**Addendum Number Two**

Drawings and Specifications Dated July 27, 2017 – Bid Set

**20 Thames Street,**

Archetype, P.A.

1 SECTION
55.02 3/4" = 1'-0"

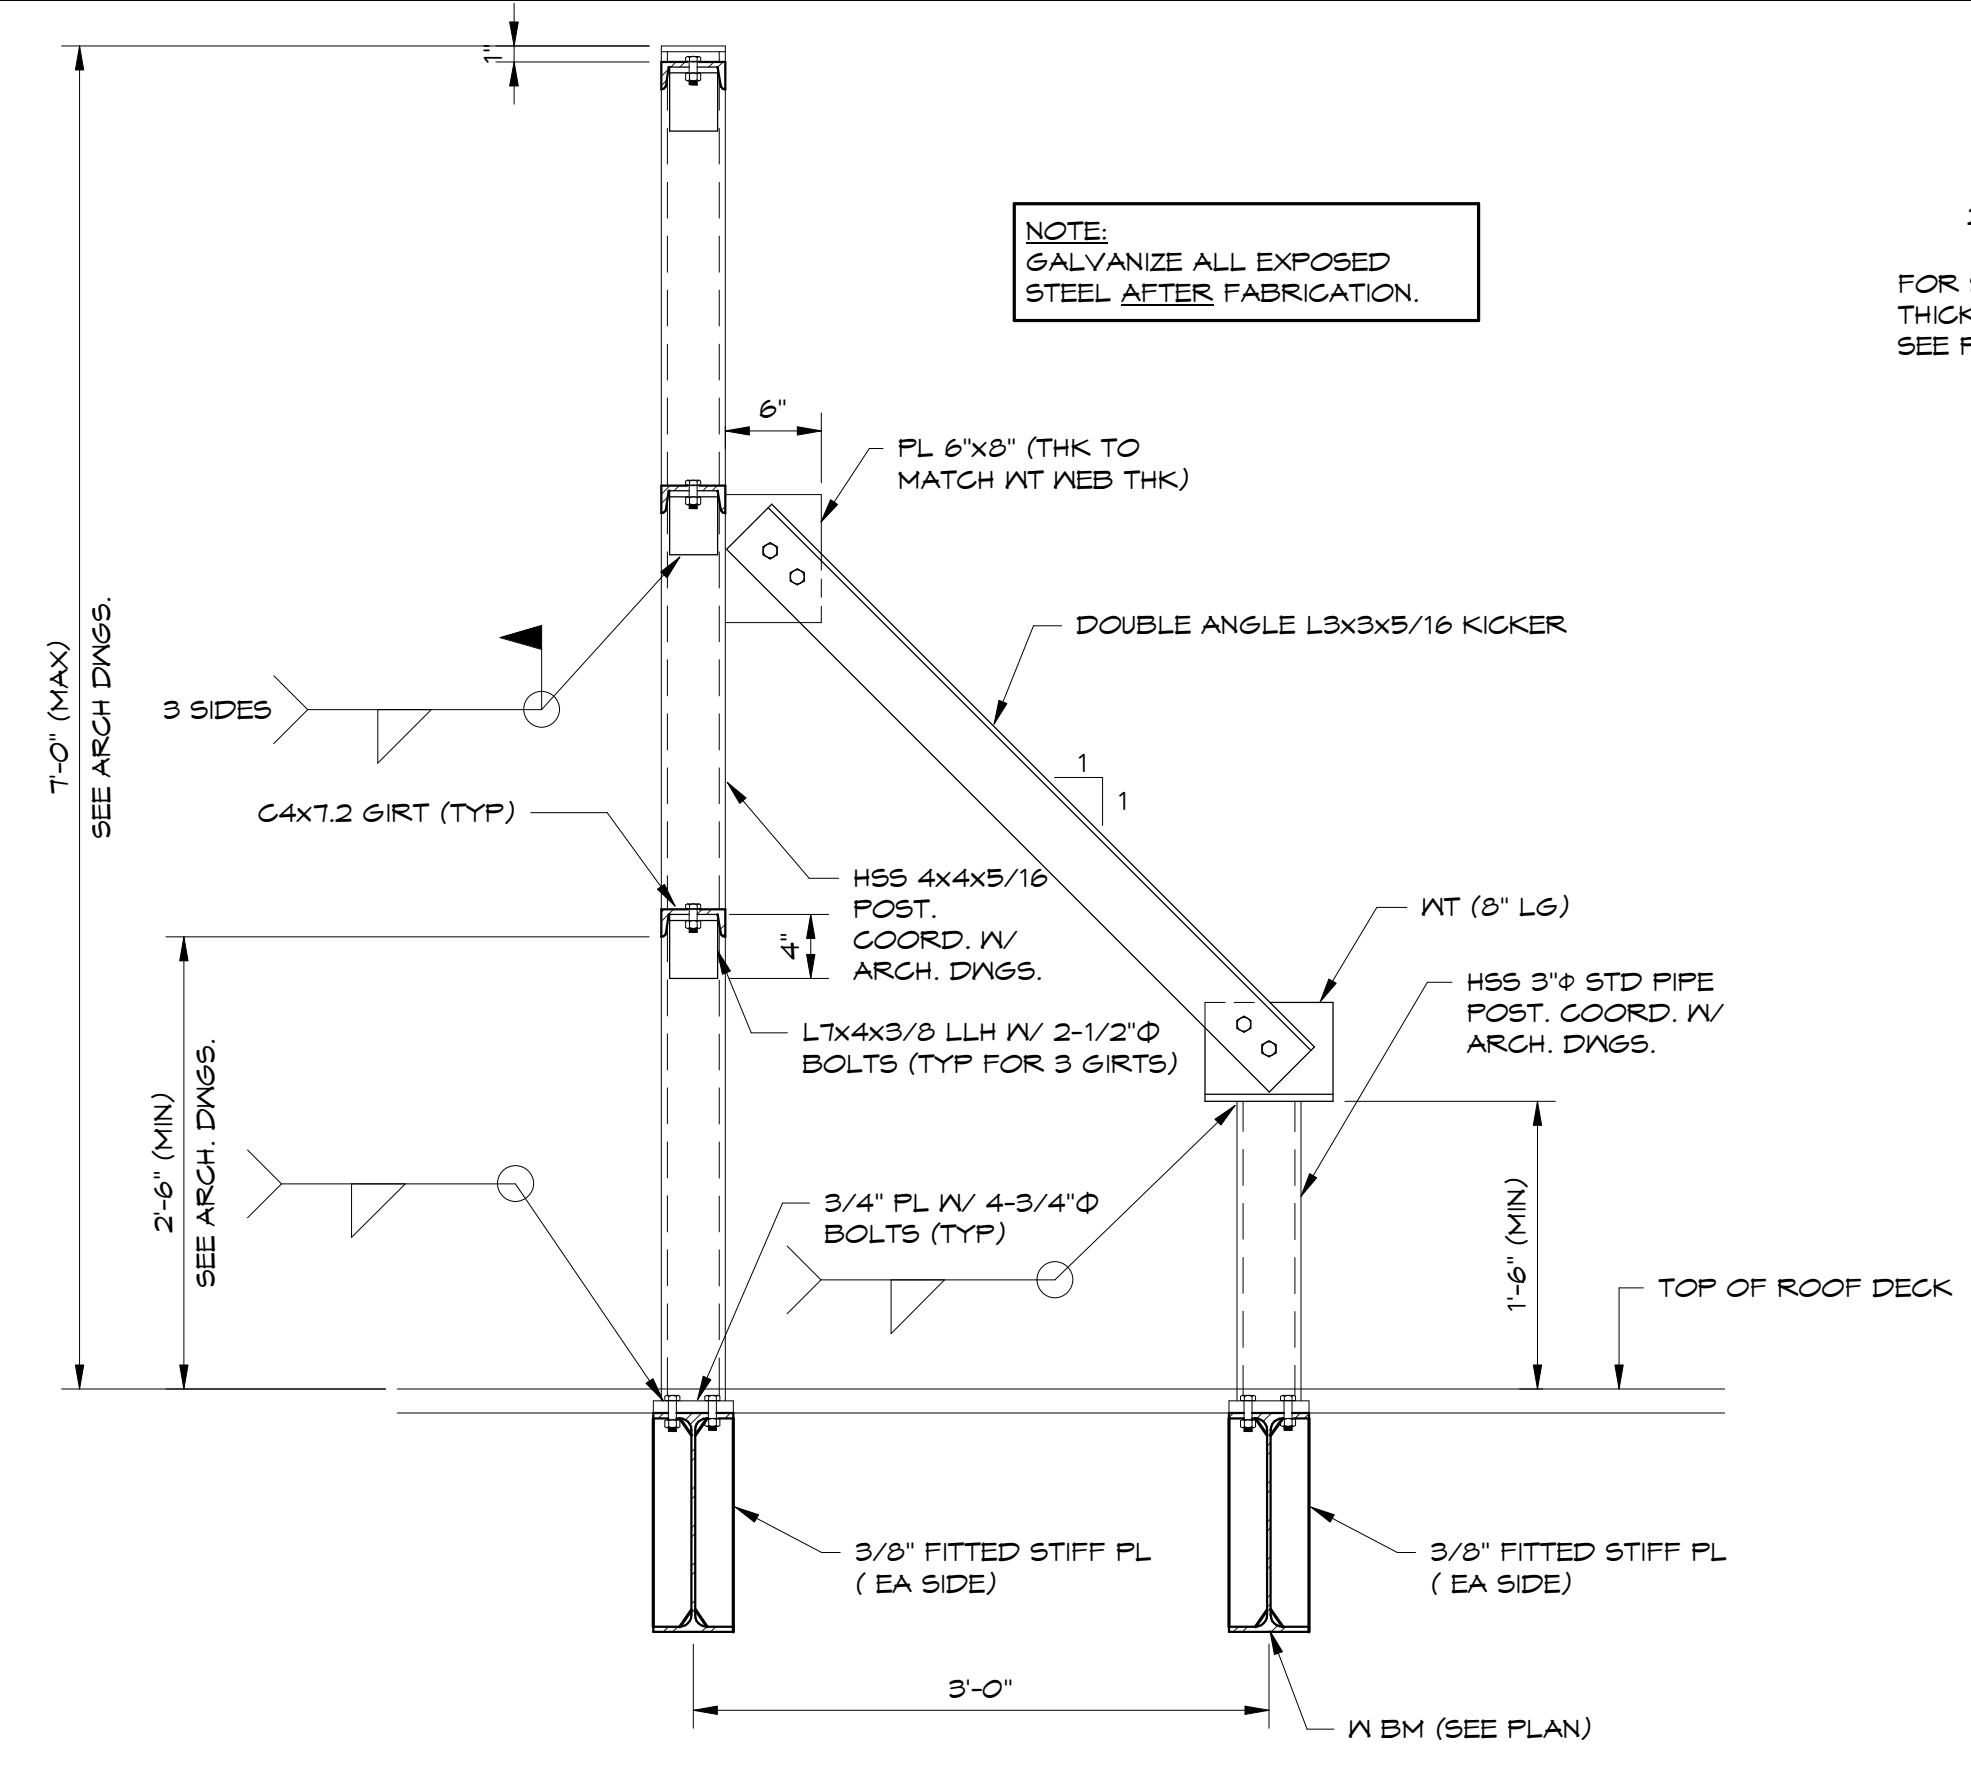
20. The tube steel running along column line A on S1.02 references section 2/S5.02 which indicates that the tube steel supports a sun shade. No sun shade is indicated in this location on the architectural drawings. Please amend drawings as necessary.

21. The tube steel running along column line BB on S1.02 also references section 2/S5.02. No sun shade is indicated in this location on the architectural drawings. Please amend drawings as necessary.

**Response: S1.02 has been updated. We don't have sunshades along gridline A at the second floor**

**Response: S1.02 has been updated. There is no sunshade along gridline BB, but there is one along gridline AA**
